Our Ref: Y/147/20/DOC

**Approval of details reserved by condition imposed under ref APP/C3810/V/16/3158261 (Y/19/16/OUT)
relating to Condition Nos 5 - surface water drainage and 6 - foul drainage system**

Land of Burndell Road Yapton

Drawing Title
**SURFACE WATER PUMPING STATION
OVERFLOW LONGSECTION**

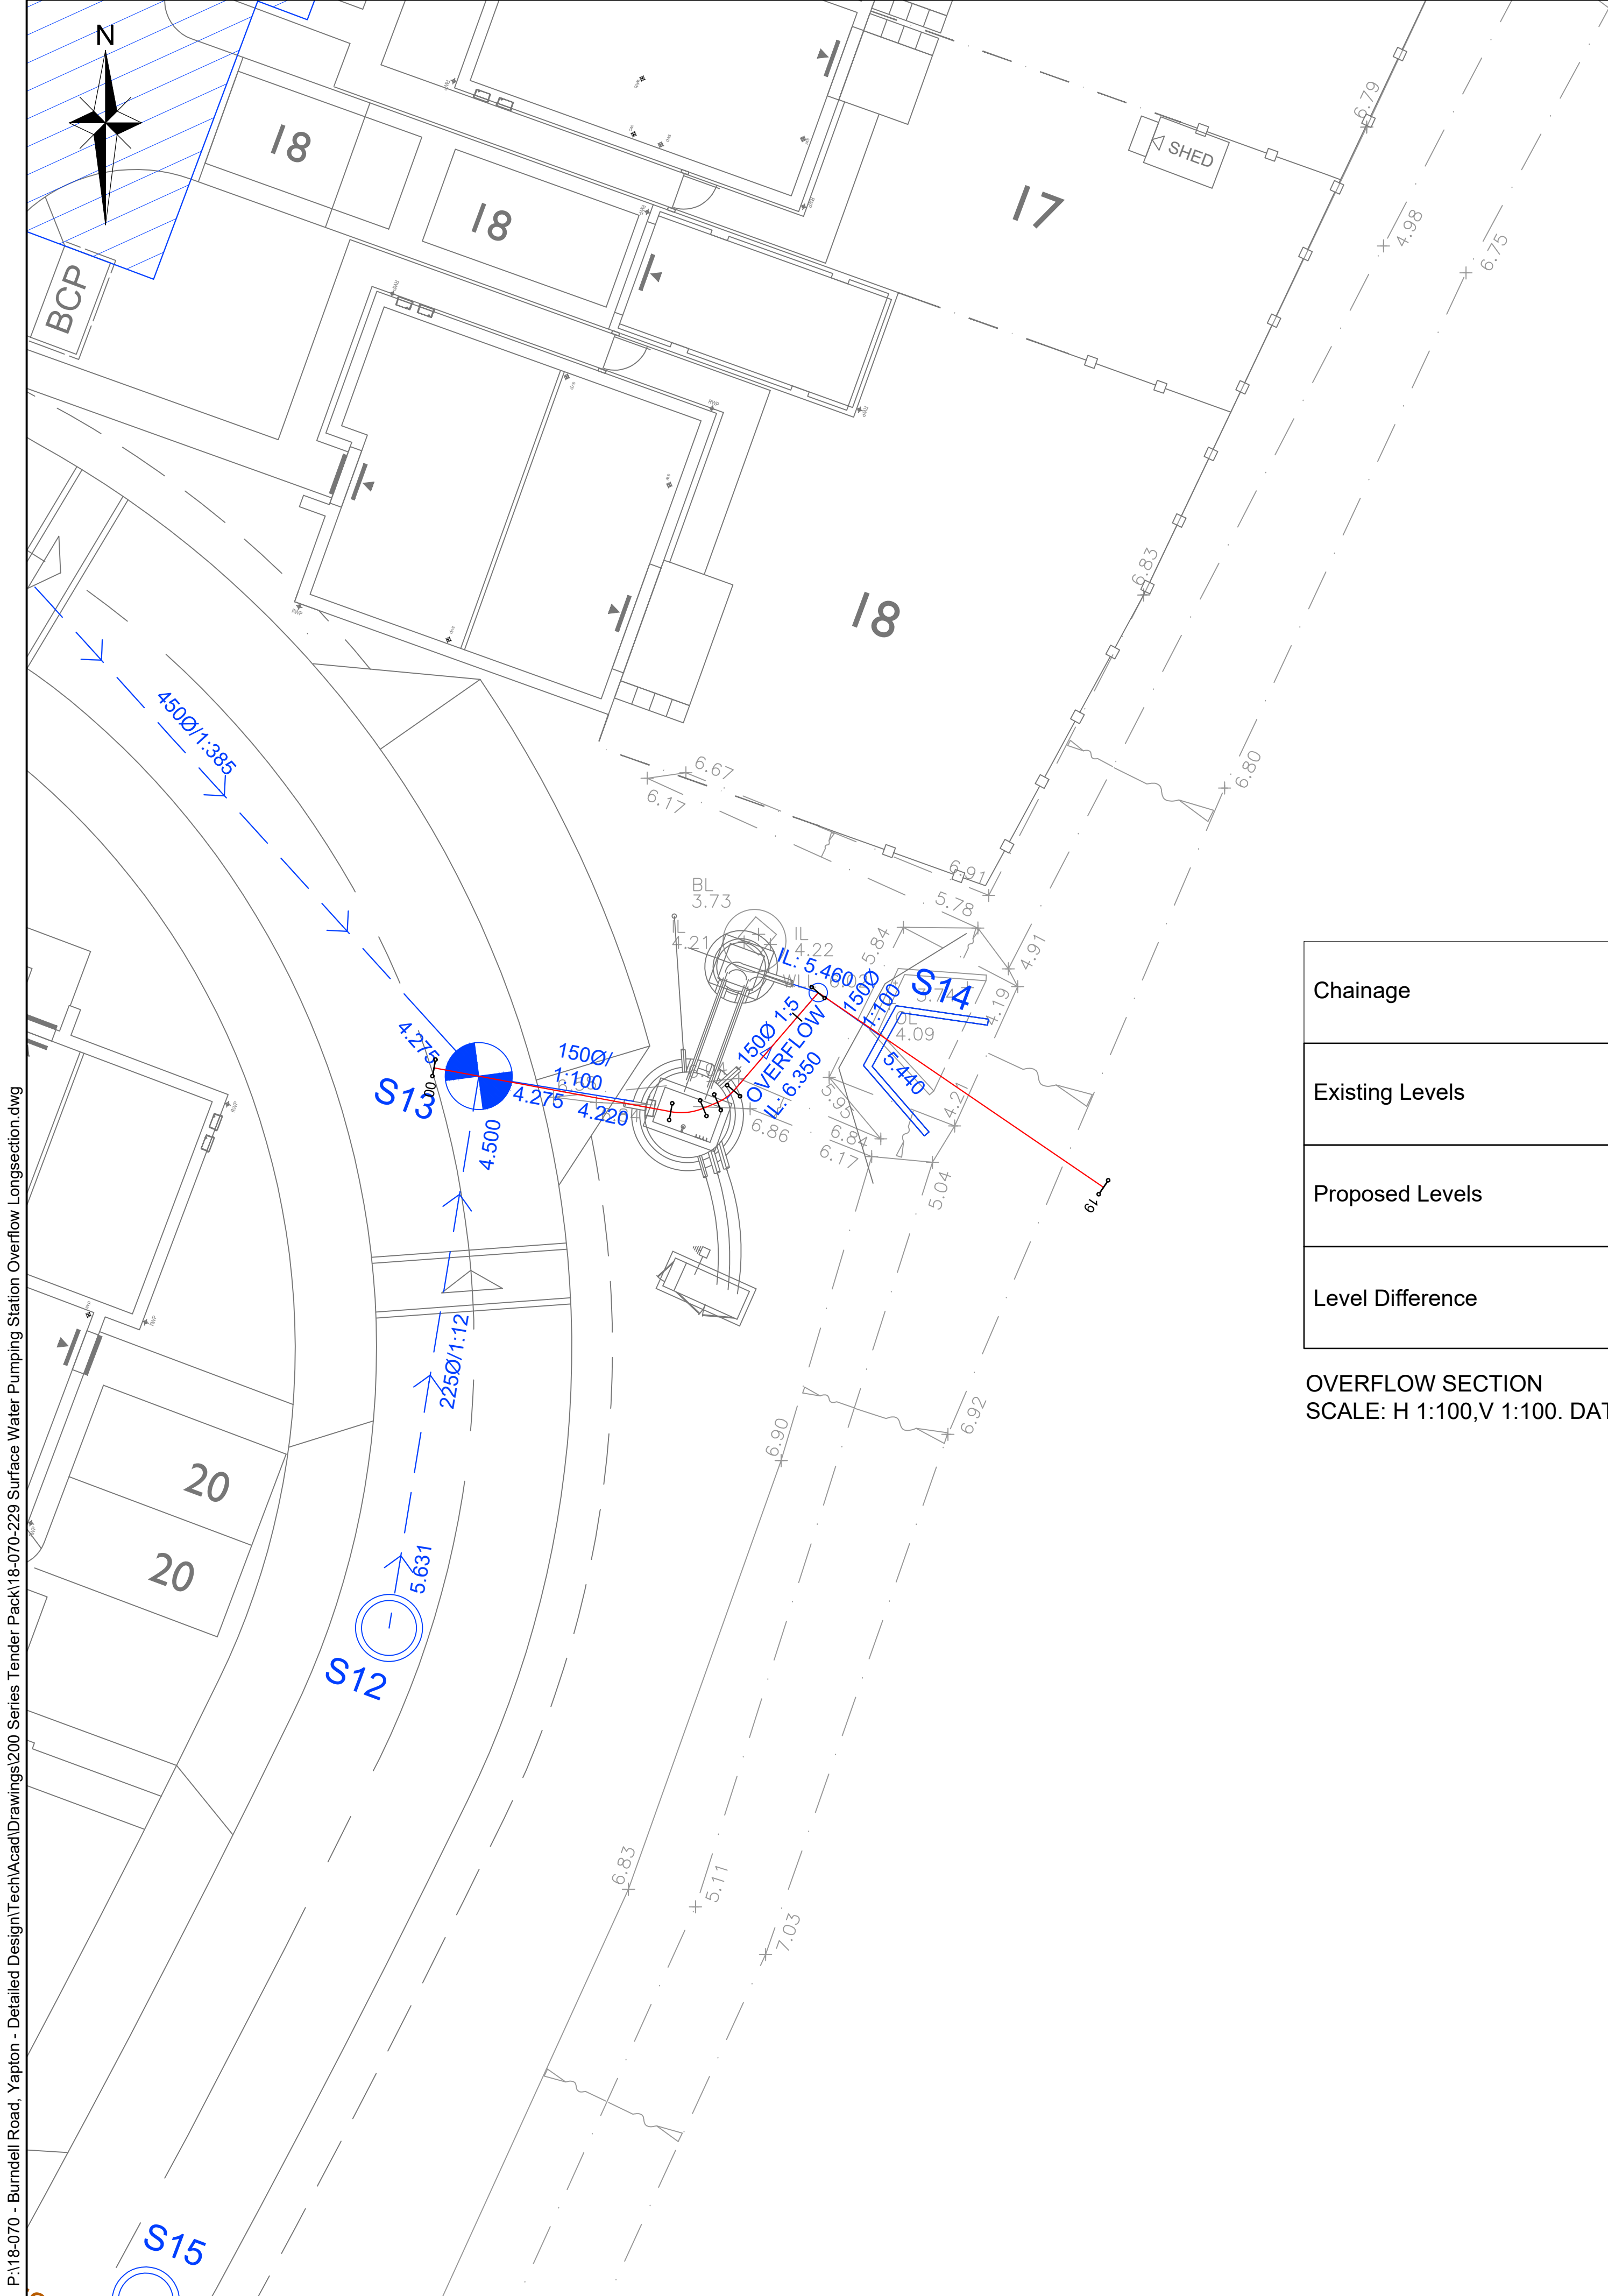
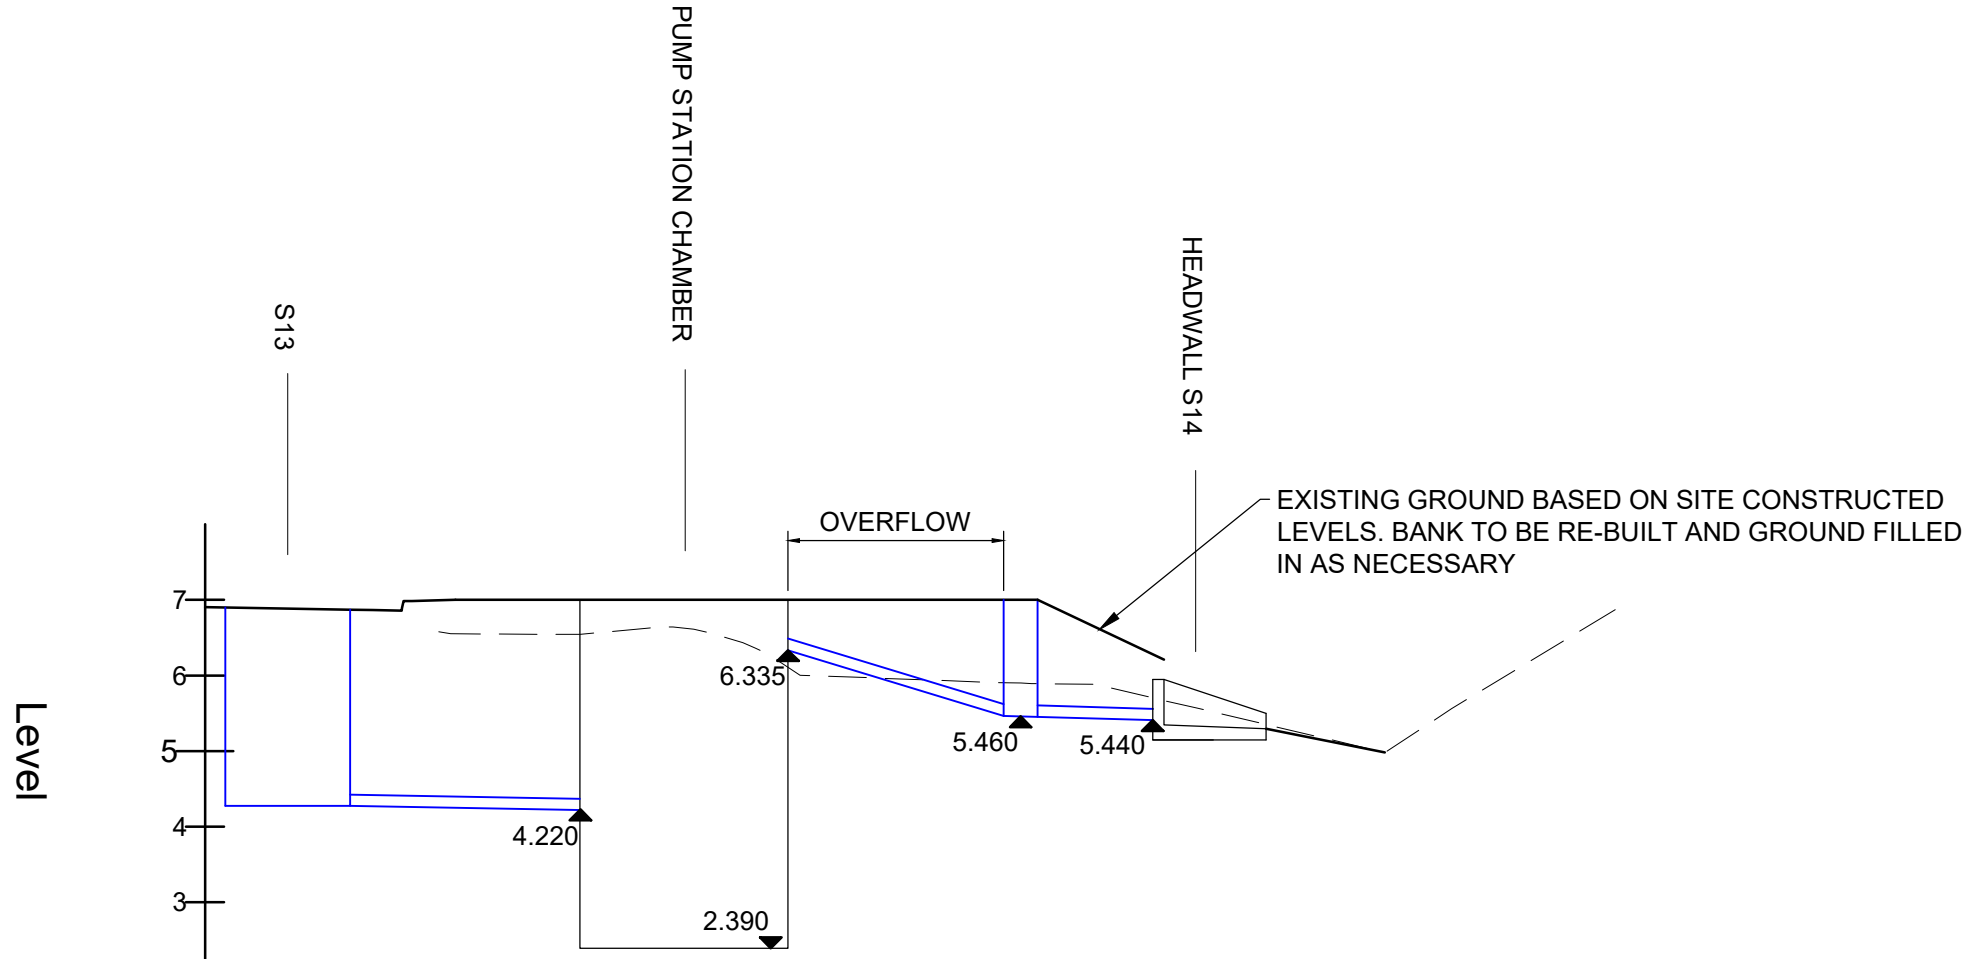
The Councils Drainage Engineers object to the proposed pumped solution and do not consider that the 18-070 "Drainage Note" (Jan 21) provides suitable justification or addresses their stated objections. The Local Planning Authority has considered the circumstances of your situation but concurs that a pumped solution is not appropriate. We would therefore request that you investigate alternatives.
